KITTTITAS COUNTY COMMUNITY DEVELOPMENT SERVICES

RE: Ben Davidson Short Plat (SP-07-11)

The Kittitas County Community Development Services Department has determined that the Ben Davidson Short Plat is a complete application and hereby grants **conditional preliminary approval** subject to the following conditions:

BEN DAVIDSON REVISED 4 LOT SHORT PLAT

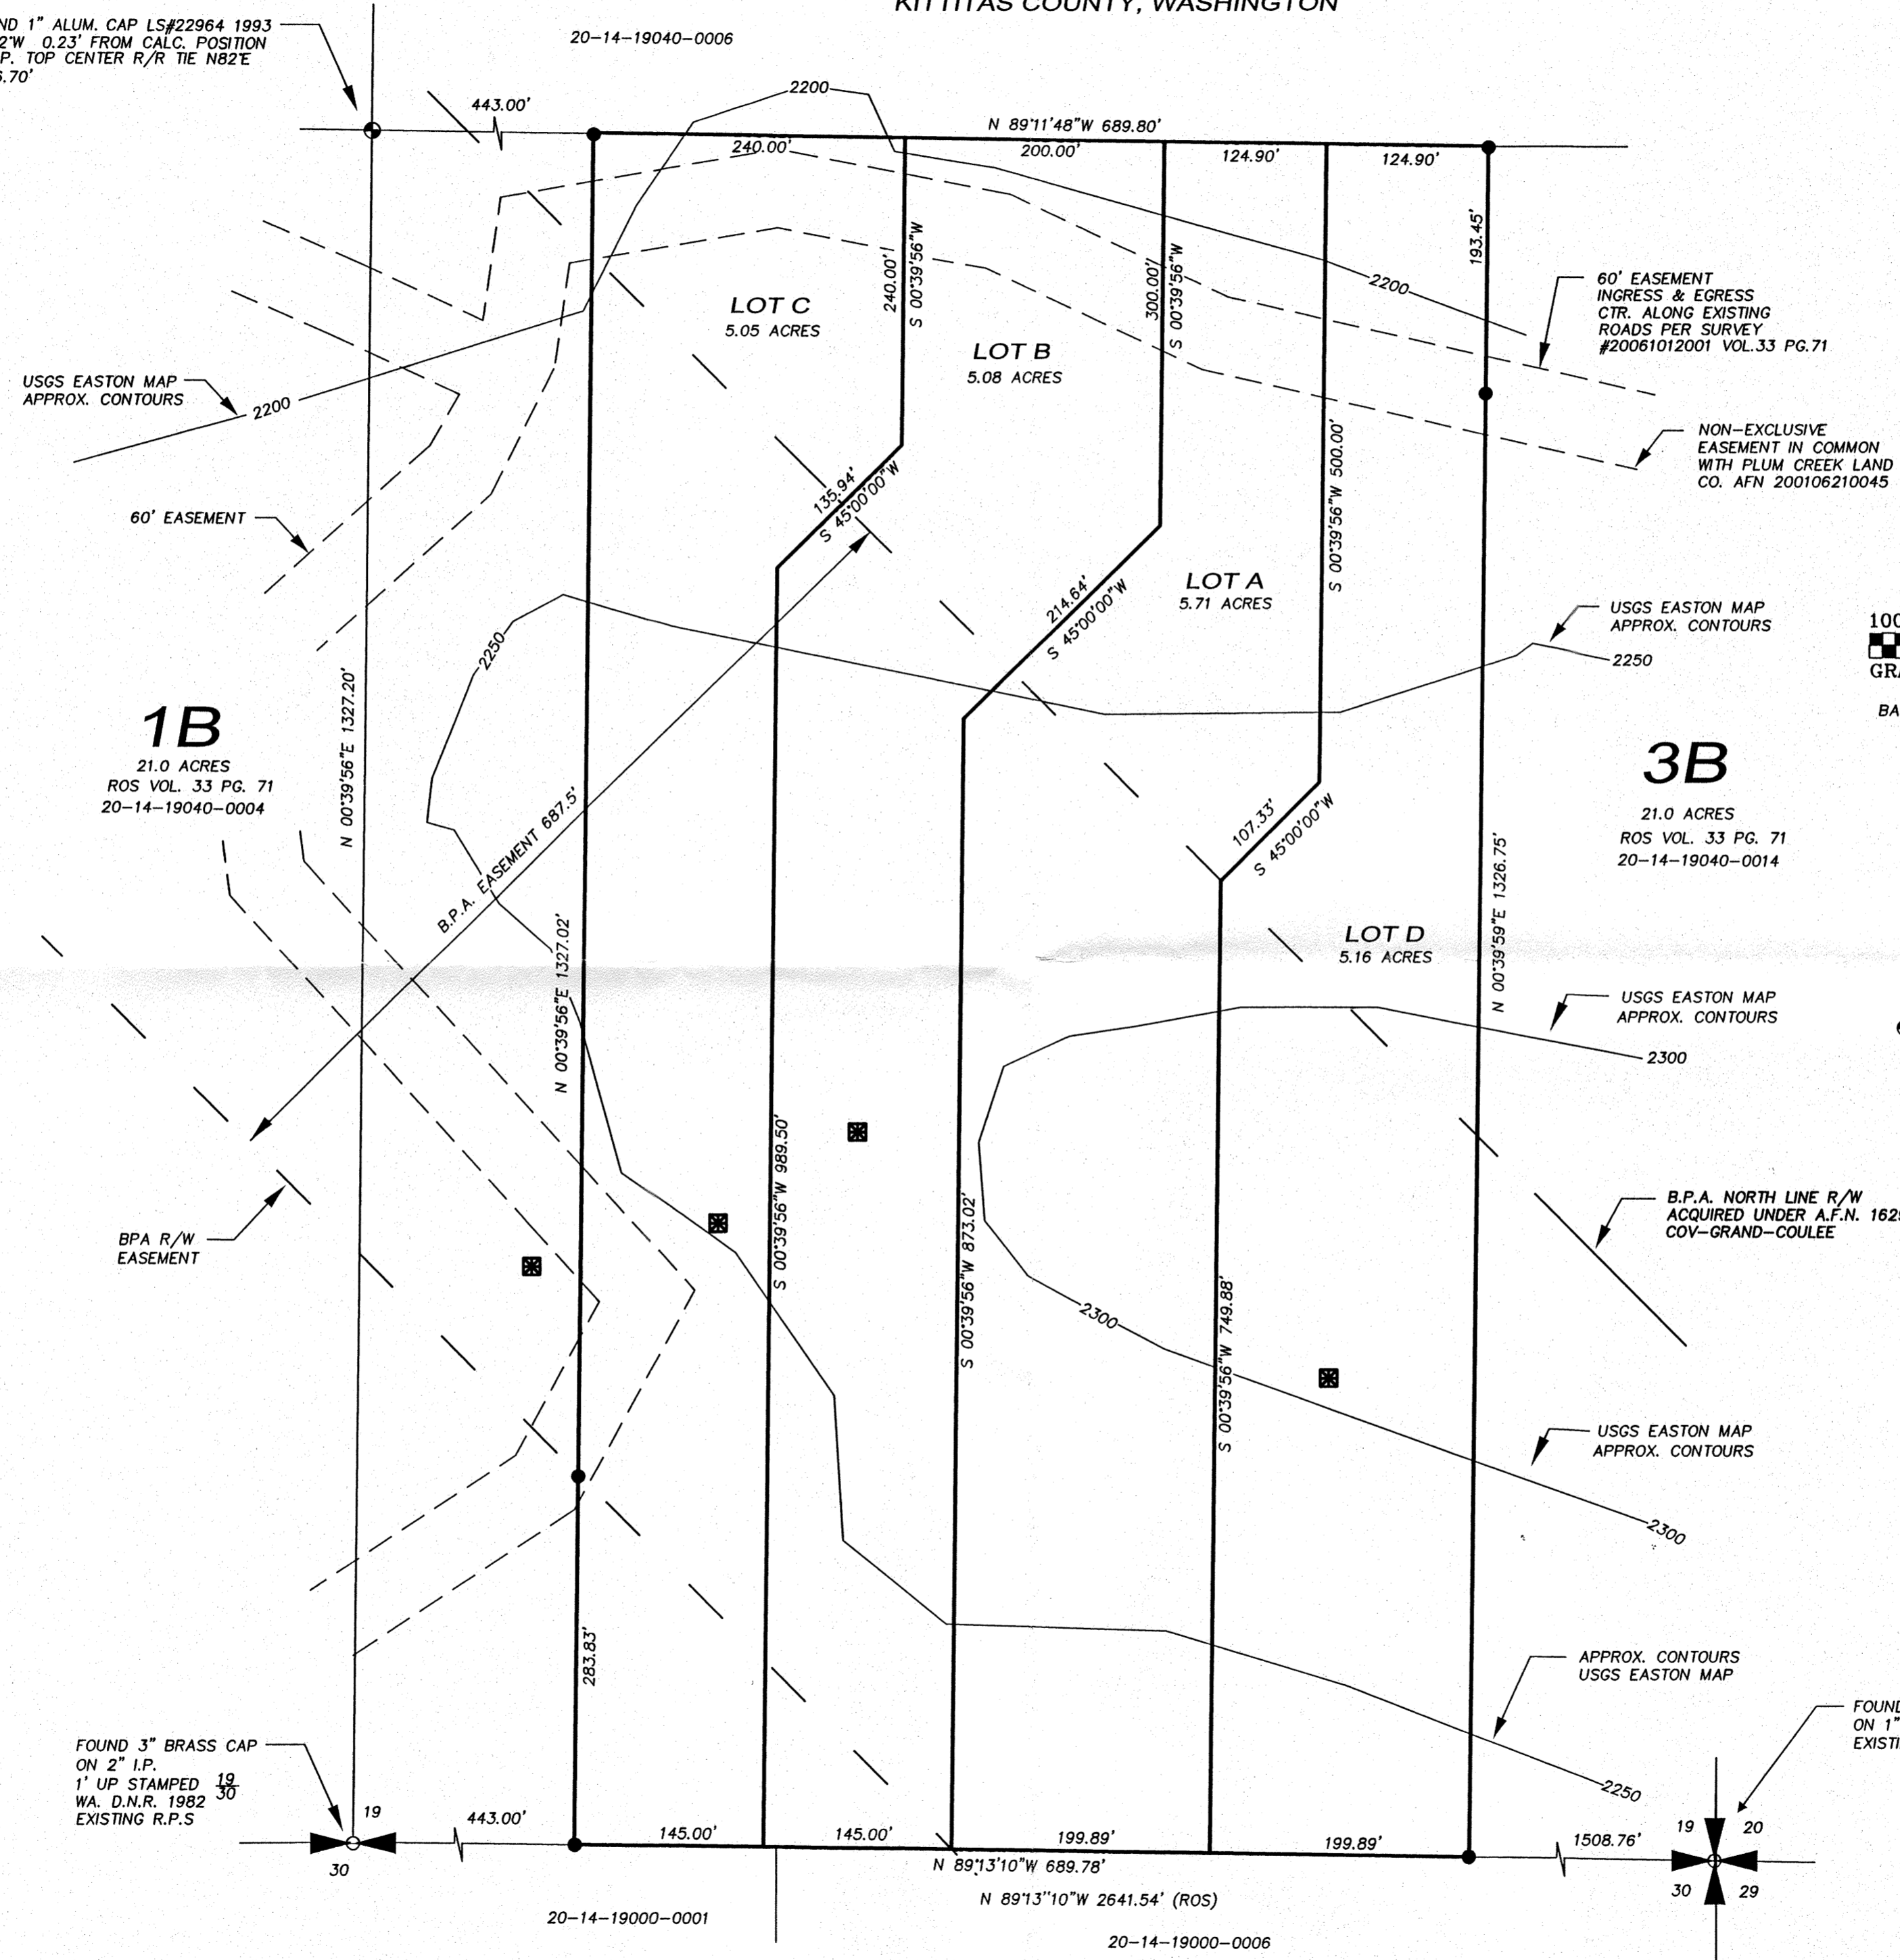
1. Both sheets shall reflect the short plat number SP-07-111.
2. All mitigations as set forth in the SEPA MDNS issued on October 8, 2007 shall be conditions of approval and of the project. Please see attached MDNS.
3. A **plat note shall be added** as follows in reference to the BPA easement located on the property:

The Bonneville Power Administration (BPA) imposes certain conditions on the portions of these lots encumbered by its high voltage transmission line right-of-way. BPA does not allow structures to be built within the right-of-way, nor does it allow access to be blocked to any transmission facilities. Prior to installation, BPA needs to agree to any activity that is to occur within the right-of-way.
